LOCATION 315 Park Ave

Permit No: 04-0023	Date Applied For: 01/12/2004	CBL: 066 F001001
------------------------------	--	----------------------------

Proposed Use: Office/ Warehouse: 10,000sf Tenant Fit-up	Proposed Project Description: Office/ Warehouse: 10,000sf Tenant Fit-up
---	---

From: Mike Nugent
To: internet:mm.arch@rcn.com
Date: Mon, Feb 9, 2004 10:20 AM
Subject: 315 Park Ave

**STAIRS/DETAILS**

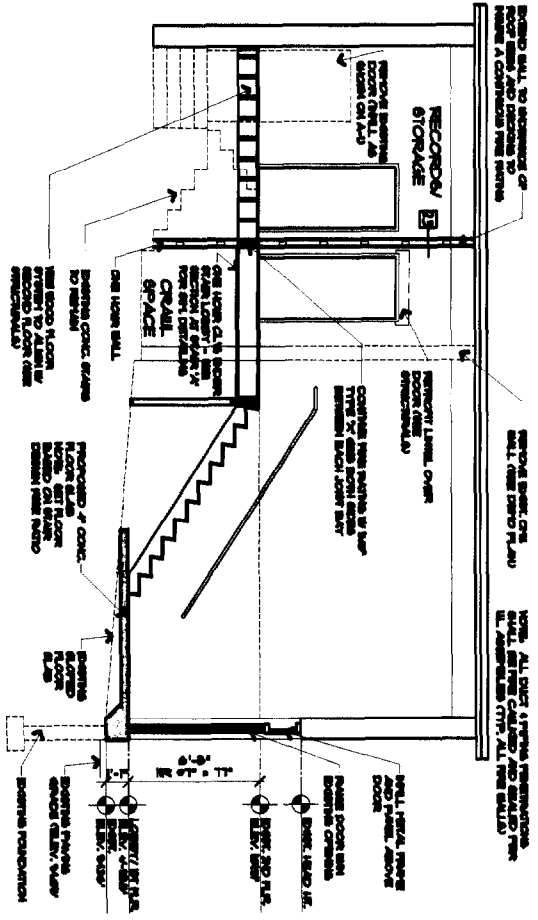
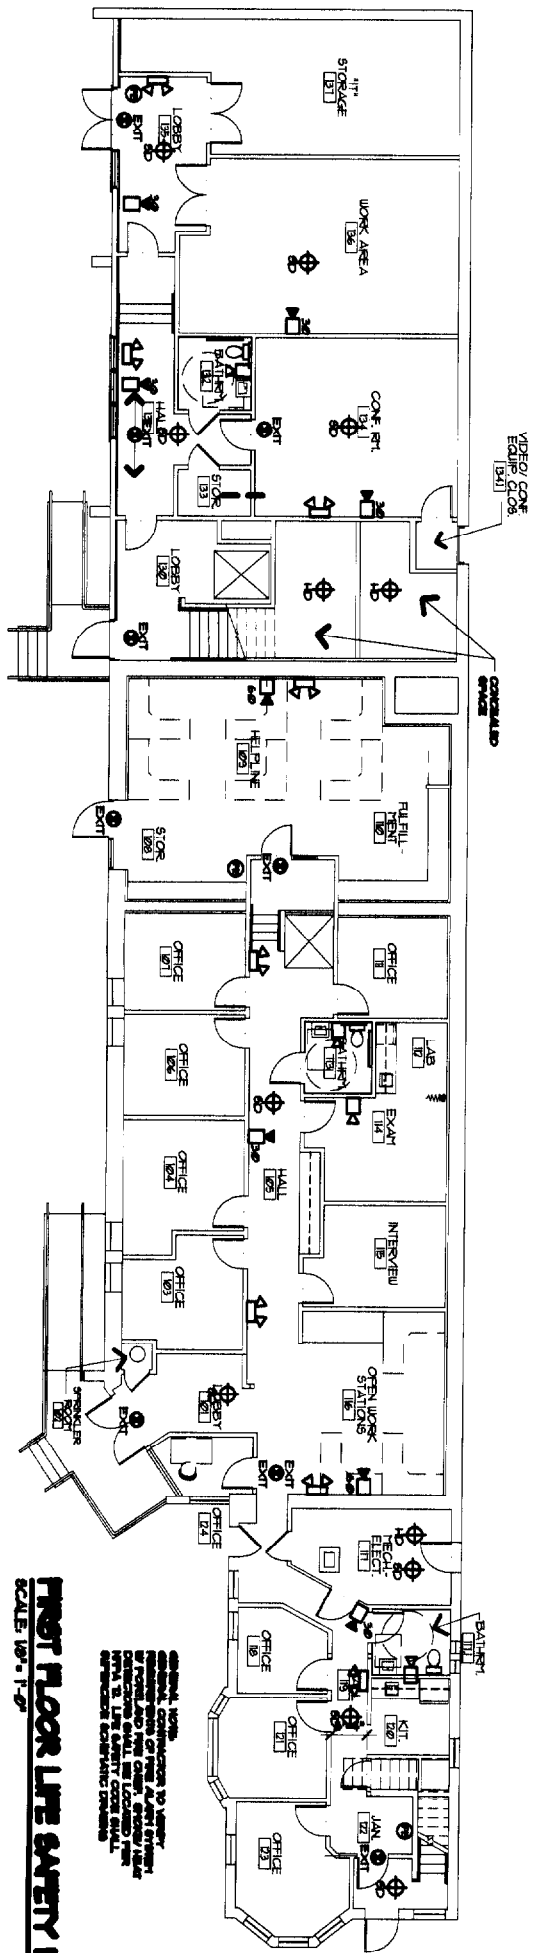
- 1) What are the tread dimensions for stairway "A"?
- 2) For the window in this stairway, if there is not safety glazing, there should be a guard that complies with Section 1021. of the Code. Can you commit to what we will be likely to see?
- 3) The engineer makes reference to the 1996 BOCA Code in her general notes, can this be corrected (1999)?
- 4) The engineer has general language about Special Inspections for bolts, weld etc and I don't see this type of construction in the plans, are these just standard notes?
- 5) Who is doing th HVAC Design and I assume that someone will be applying for a separate permit for this?

- 1) Tread depth for stair "A" shall be 11" w/ a 1" back cut.
Risers shall be 6 11/16".
See plan and section detail on sheet A3.
- 2) The window in question is existing and the bottom of window is approx. 72" above the new landing height.
Given this additional height we plan on just leaving the existing window intact.
- 3) Yes, all work has been designed to meet standards of 1999 BOCA. I will have the structural engineer forward you a letter regarding this matter.
- 4) Yes, all new work is wood frame and therefore special inspections will not be provided.
- 5) Maine Medical Center has recommended that Doten Construction hire Dan Libby (South Portland) as the HVAC designer and contractor. He will be responsible for obtaining his own permit through your office.
